Response to LHA Consultation Planning Application Ref: 6/2018/3292/MAJ

- 1.1 Mayer Brown Limited (MB) has been appointed by Marbrook Care to provide highways and transport related assistance in relation to the new planning application for the redevelopment of 43 to 54 Broadwater Road in Welwyn Garden City, Hertfordshire. The redevelopment comprises the construction of a 104-unit care home (comprising 91 bedrooms and 13 one-bedroom suites).

Date: 29/04/2019

drawing number **BPWELWYNGC.1/TK05** | rev. **A**

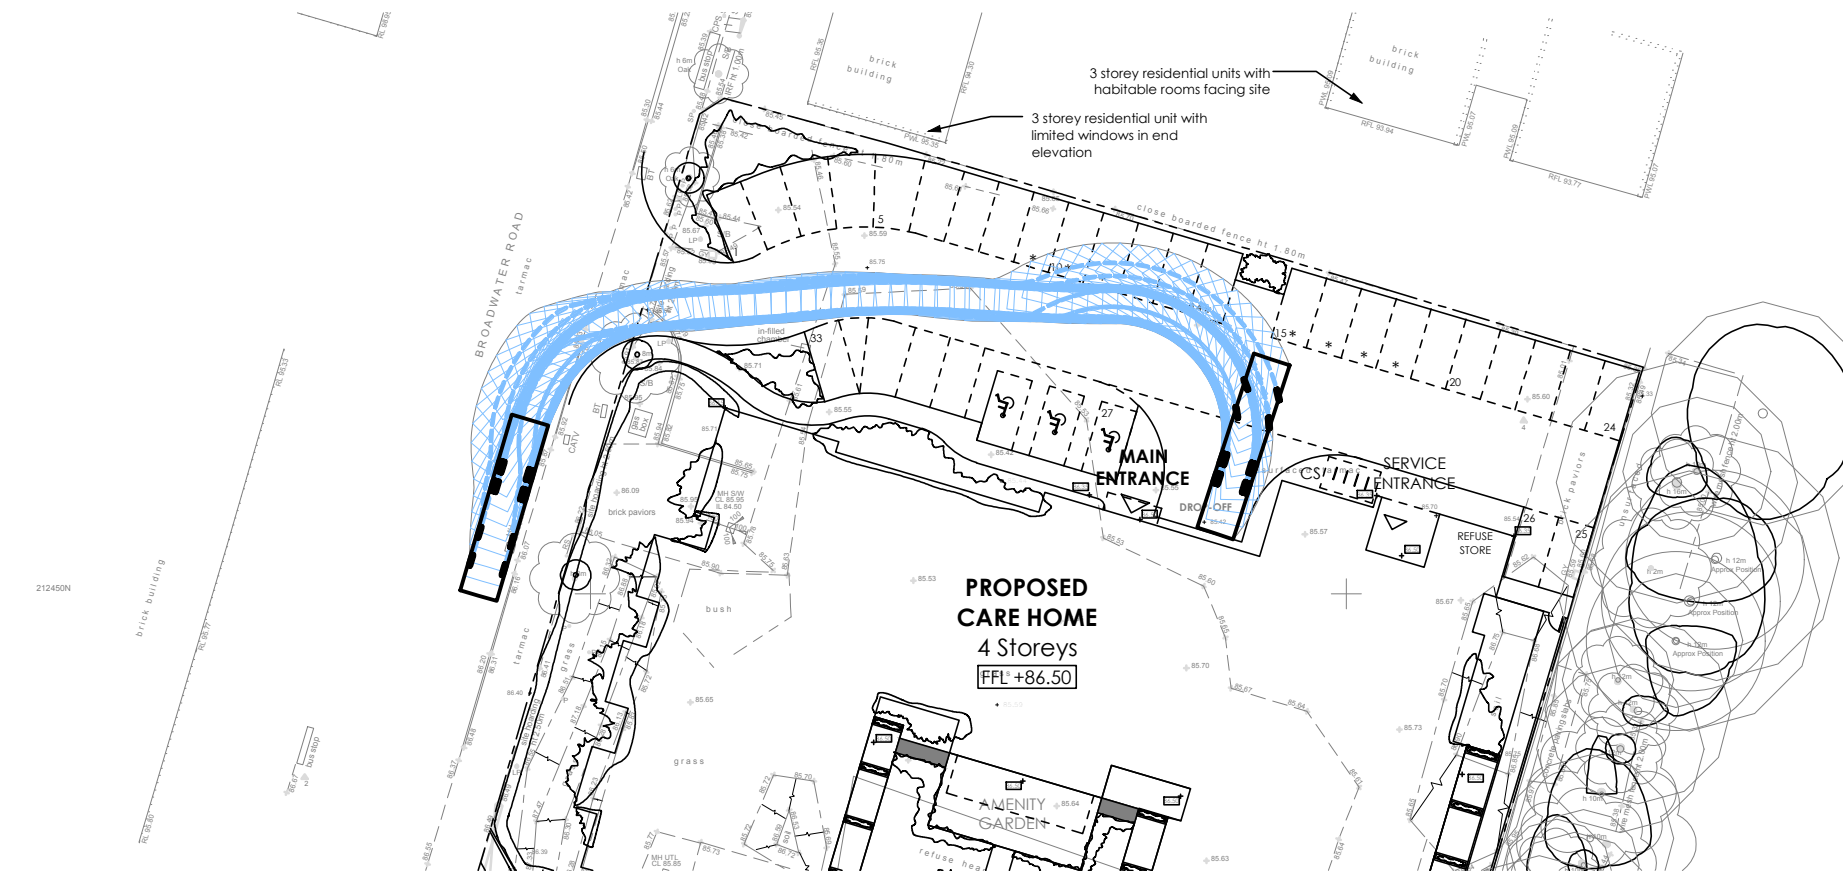
“The revised layout in terms of vehicles presents the Highway Authority with significant concern. Whilst drawing BPWELWYNGC.1/TK05 Rev A provides swept path for refuse lorries (12.1m) it is necessary to observe that the ability for such vehicles to turn within the site requires 10 parking spaces to be empty (such spaces all adjacent to each other). Servicing therefore requires approximately 1/3rd of the total car parking capacity to be vacated

Noting the reliance on removal of parking for servicing, and absence of any firm detail on how this is managed, the HA recommend the LPA assess the development proposals against the level of parking available when areas for turning are needed i.e. 23 spaces.

In the absence of firm arrangements for the protection of spaces for servicing, and recognising that bin stores are a significant distance away from the highway, the Highway Authority present concerns that the servicing of the development shall have an unacceptable impact on the safety and efficiency of the local road network, either by displacing upto 10 vehicles weekly onto local roads already experiencing high degrees of parking demand and potentially resulting in unsafe or obstructive parking, or by forcing refuse vehicles to reverse out of the site prejudicial to the safety of other highway users. For this reason the Highway Authority recommend that the application be refused”.

- 1.16 It is not unusual for developments of this nature to require some form of car parking management in order to facilitate on-site refuse collection. The TS referred to a large refuse vehicle with a length of 12.1m, details have since been obtained from WHBC regarding the specification of the exact vehicles that are used by WHBC. The swept path analysis has been revised to allow for the WHBC specified refuse vehicle. The revised swept path analysis is provided in **Drawing No. BPWelwynGC.1/TK09 Rev A** included at the back of this note. It can be seen that the revised vehicle requires eight car parking spaces to be coned off to allow access.

- 1.17 It can be seen from **Table 1.3** that the maximum parking accumulation results in eight or more spare car parking spaces at all times. Prior to 11:00 in the morning and after 15:00 in the afternoon the car park would have significantly more spare parking spaces. The spaces required for the refuse collection would only need to be coned off prior to the collection which is anticipated to be during the morning before 11:00 hours. The car park would be managed by a member of the care home staff, who would oversee the collection and ensure that the required space was available. The above demonstrates that the car park would therefore be able to accommodate the manoeuvring requirements of the refuse collection with ease.
